Environmental Health Division  
1675 W. Garden of the Gods Road  
Suite 2044  
Colorado Springs, CO 80907  
(719) 578-3199 *phone*  
(719) 578-3188 *fax*  
[www.elpasocountyhealth.org](http://www.elpasocountyhealth.org)

### **Reimers Rural Home Occupation, AL-18-013**

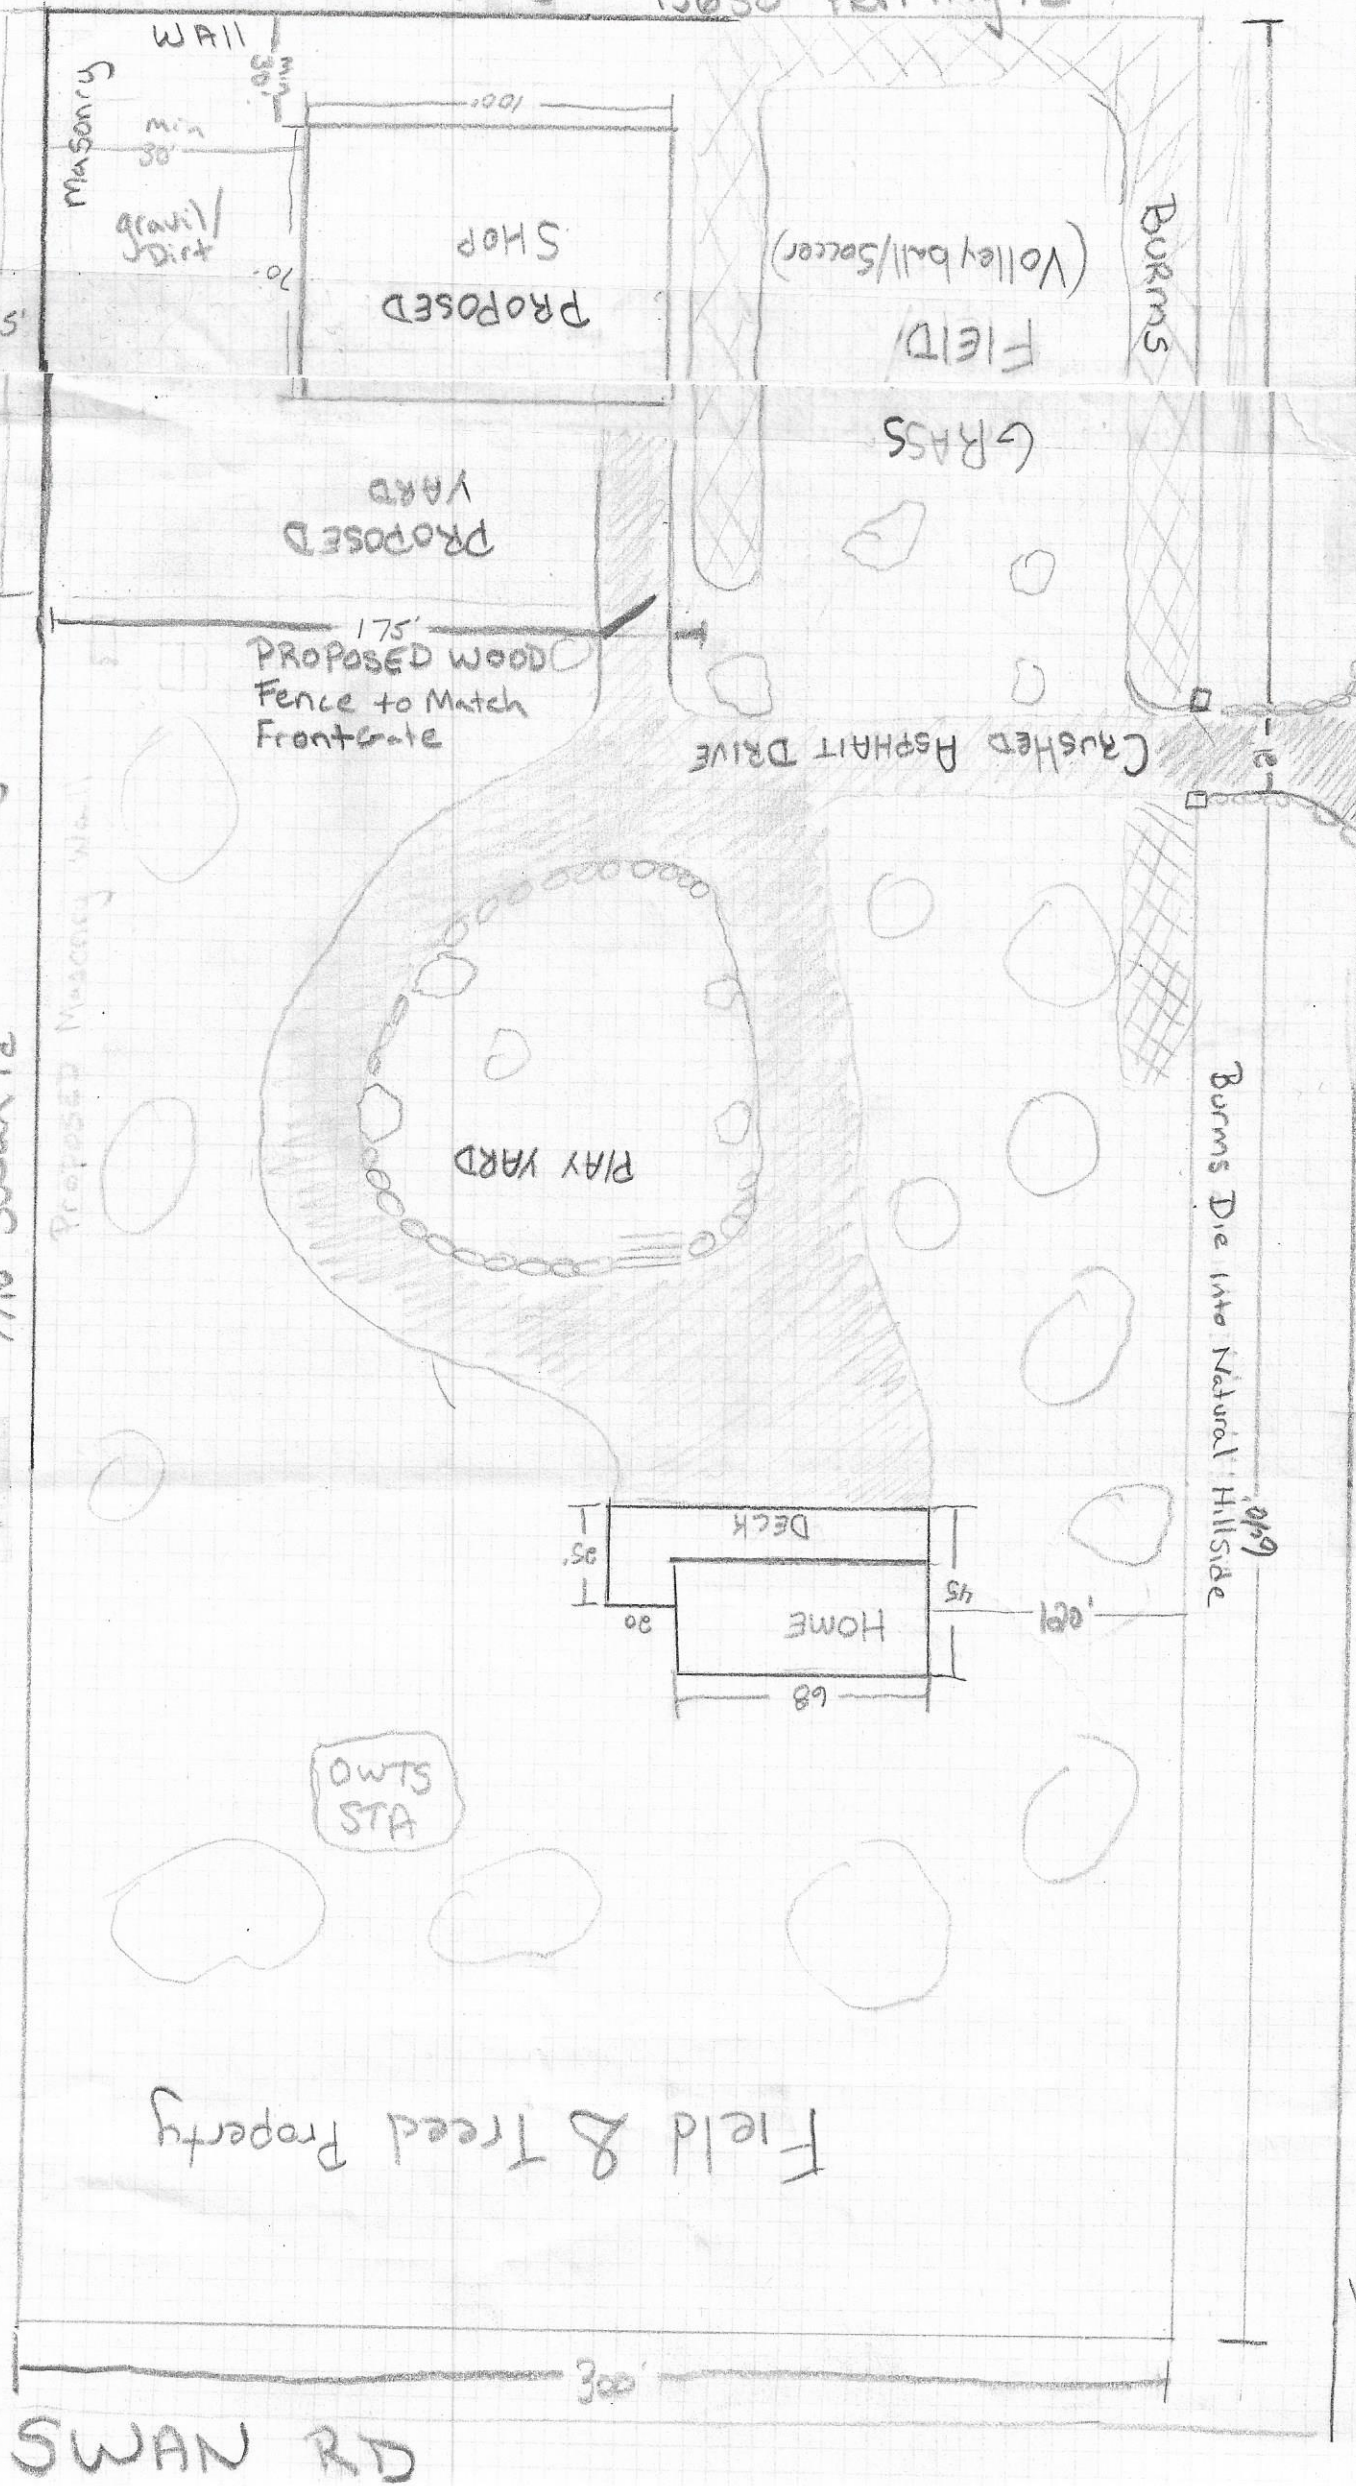
- **The onsite wastewater treatment system (OWTS) soil treatment area (STA) for the existing house must be located and protected from compaction associated with masonry business.**
- **If an OWTS is planned for employee use in the proposed 70' x 100' storage structure, then a New OWTS Permit is required.**
- **No other public health issues noted with the proposed business.**
